**KIRKLEES METROPOLITAN COUNCIL
INVESTMENT & REGENERATION SERVICE**

DELEGATED DECISION TO DETERMINE PLANNING APPLICATIONS

Reference No:	2025/62/93399/W
Site Address:	land between, 3 & 7, Boulder Gate, Marsden, Huddersfield, HD7 6LJ
Description:	Erection of detached dwelling with associated parking and landscaping
Recommending Officer:	John Holmes

Officer Report – 2025/93399

Proposed Street Scene A-A
Scale 1:200

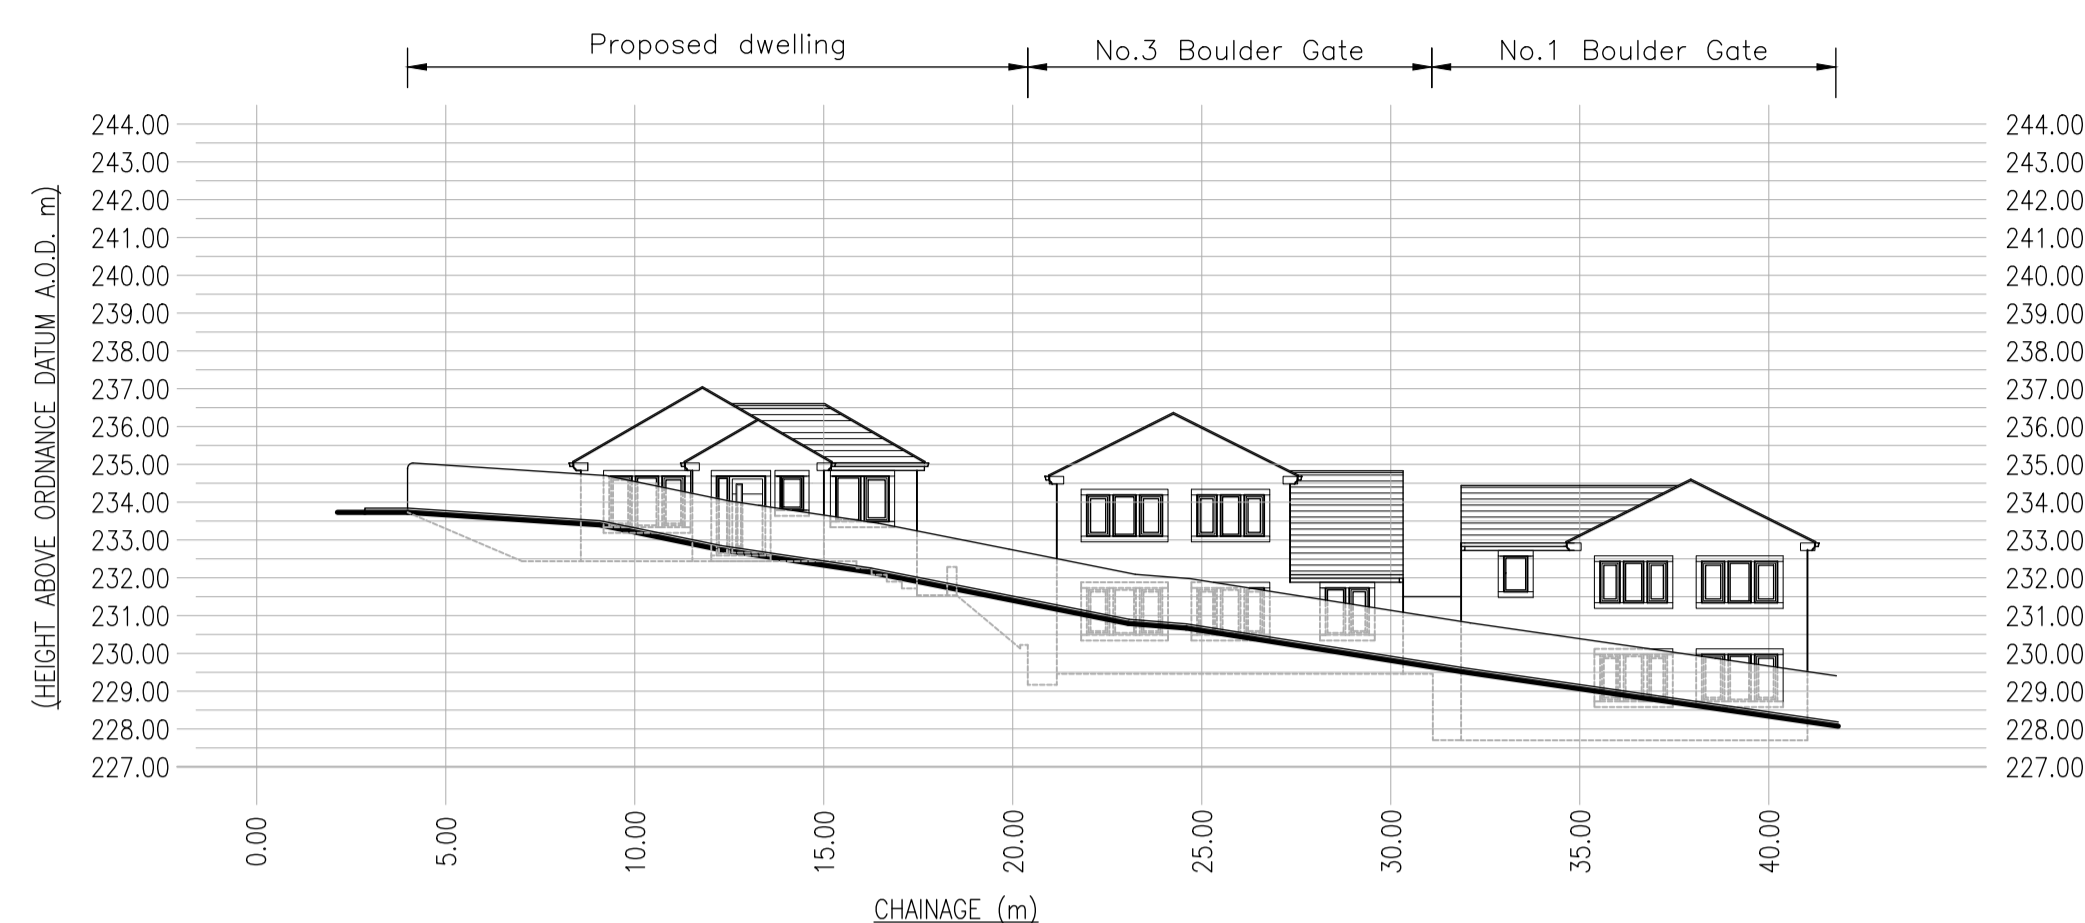
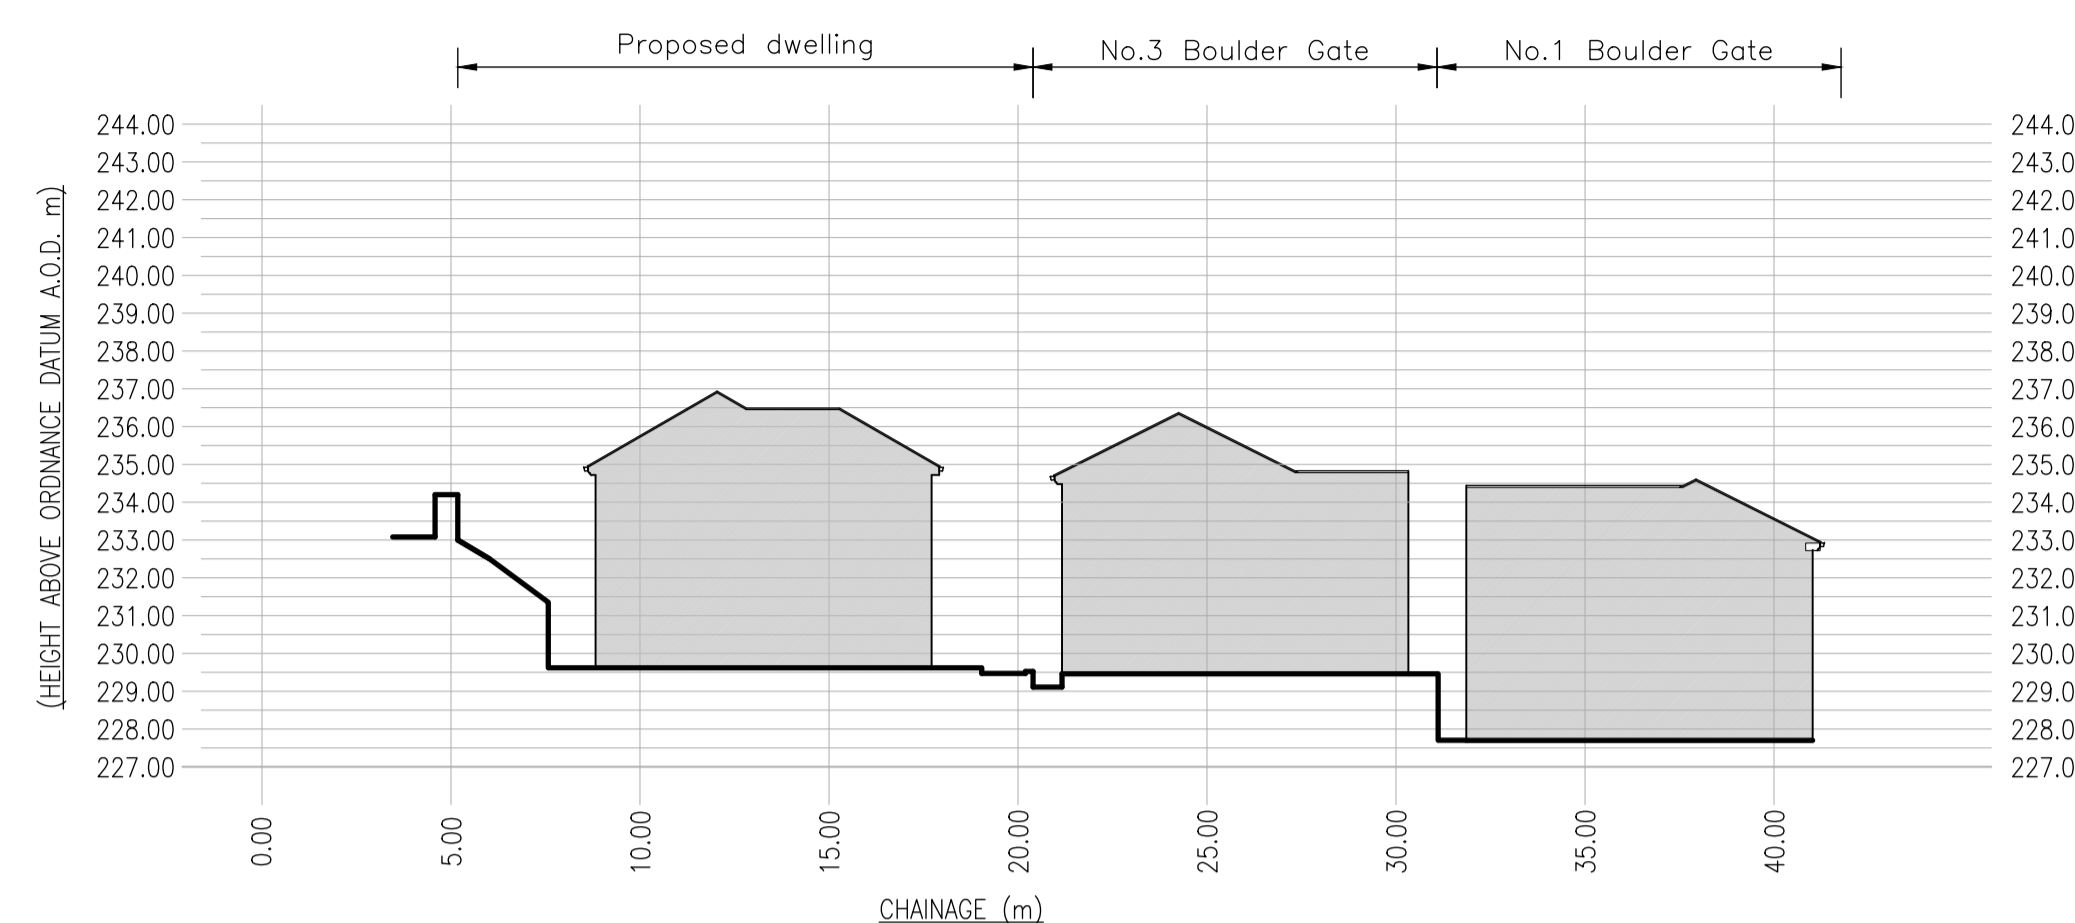
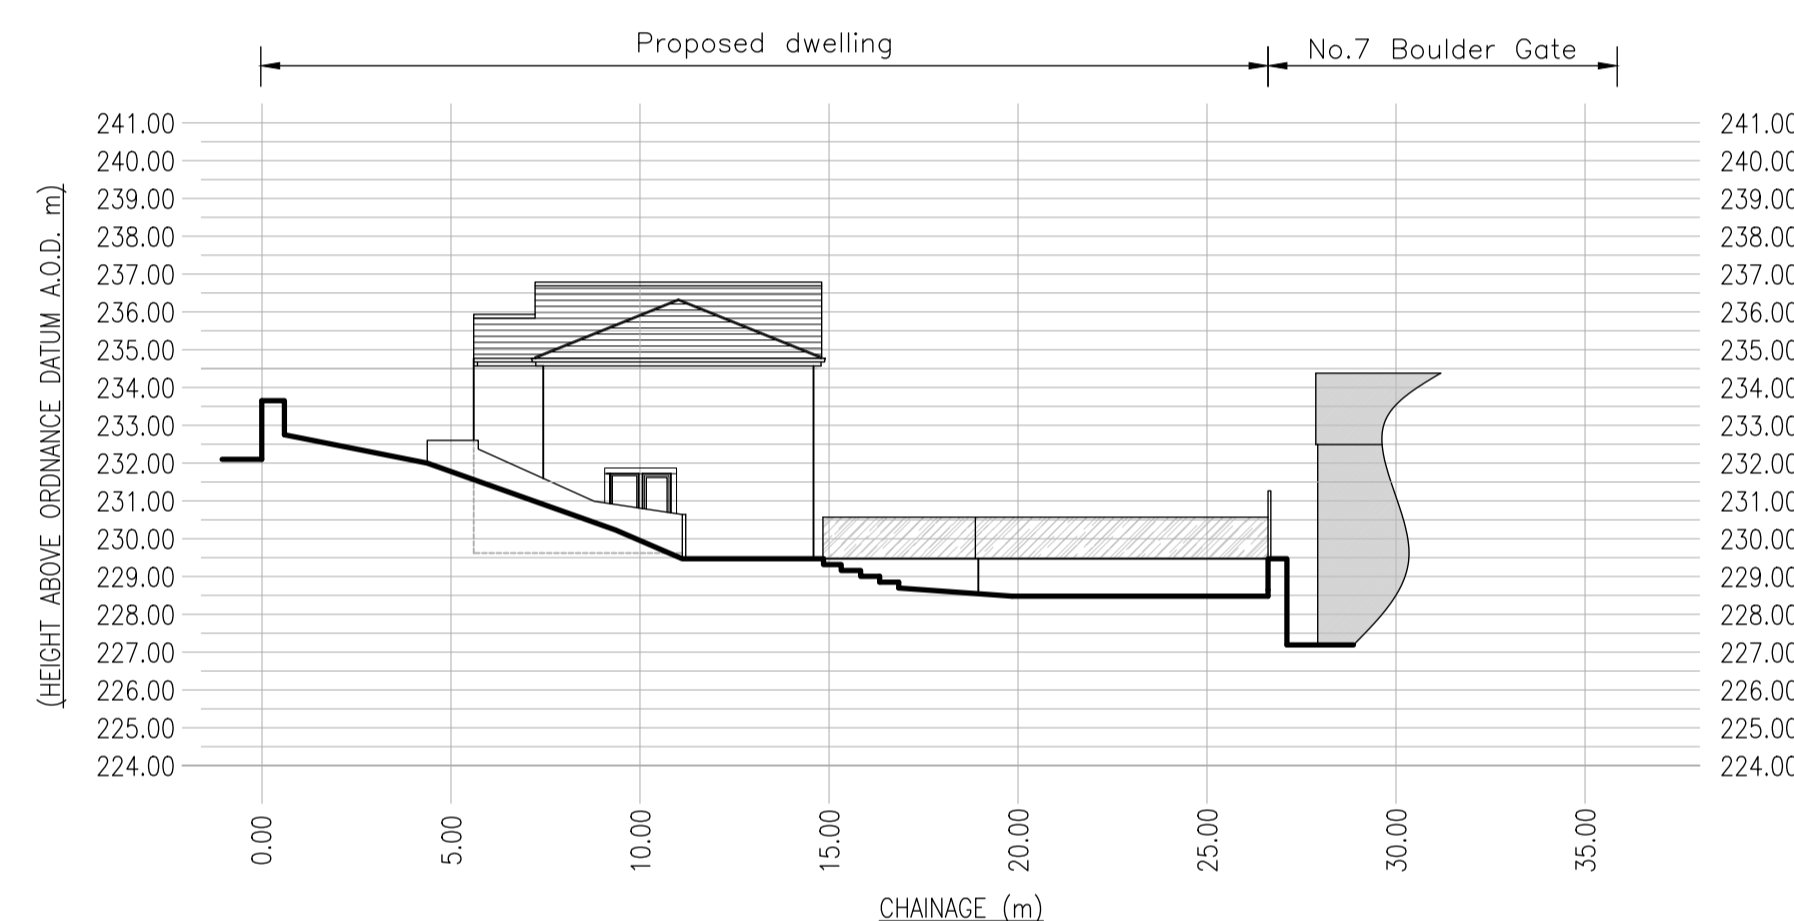
The proposal would see a large expanse of built form facing Meltham Road, the site is highly prominent and the development would still affect the ability for views to be taken across the site of the wider vistas as identified by the planning inspectorate.

The siting of dwellings adjacent to the proposed development is at a lower land level, and it is considered the proposal would be at a more prominent land level as well as more prominent location within the street.

Whilst a section is included in the planning statement, with reference to eaves and roof heights, it remains the conclusion the design, scale and overall re-development of the site as proposed would have the same impact as that which was concluded in the determination of application 2024/90652.

Proposed Site Layout
Scale 1:200

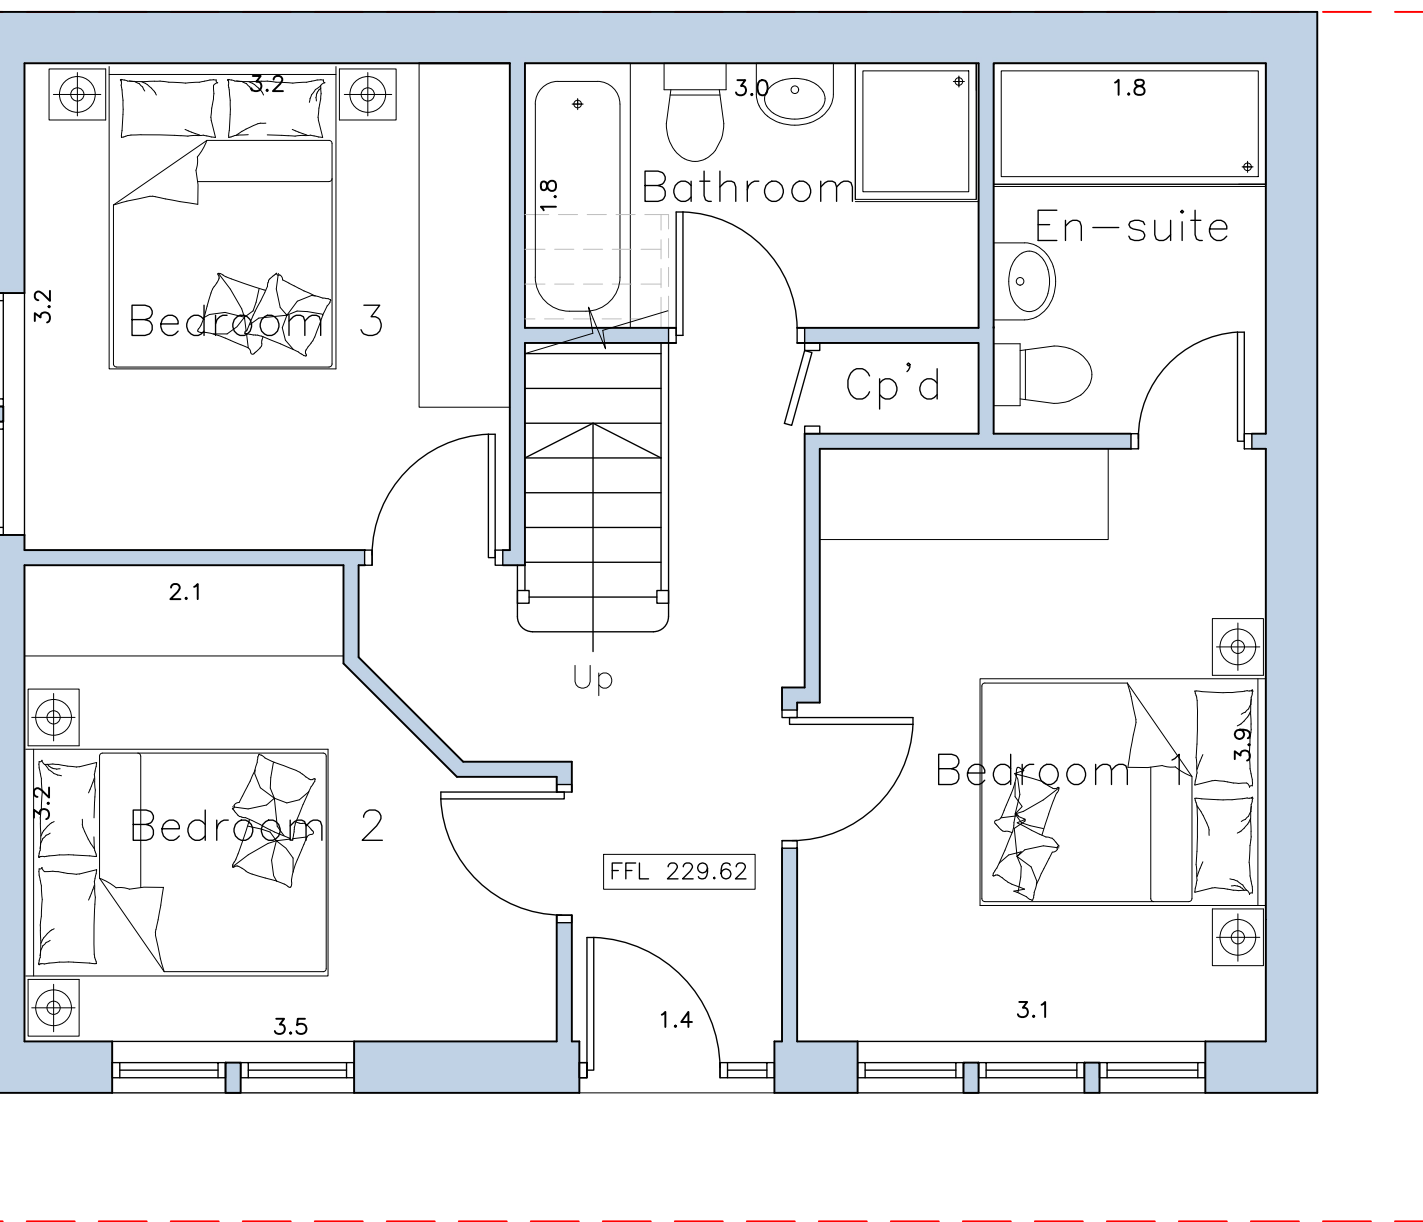
It is considered this would largely remain an issue, whilst there could be scope for a private amenity space this could only be realistically achieved through use of screening which would further impact in terms of the visual impact of the development.

Rather than being at a lower level the amenity space is at a higher part of the site which is more prominent, notwithstanding the fact it is acknowledged there is difficulty to achieve private amenity space provision given the prominence of the site it is considered this demonstrates the fact the development potential of the site is limited in this case. Its constrained size, and the topography of the site makes much of the amenity space not easily usable and it highly prominent. Pressure to create additional means of enclosure to create private amenity space would further exacerbate the visual impact that at further dwelling upon the site would have.

In conclusion the previous reason for refusal in relation to amenity space provision is not considered to have been overcome by the proposal. Given the reason relates to the prominence the amenity space provision would be, in relation to the wider locality, it is considered that reason 2 should be worded to reference this.
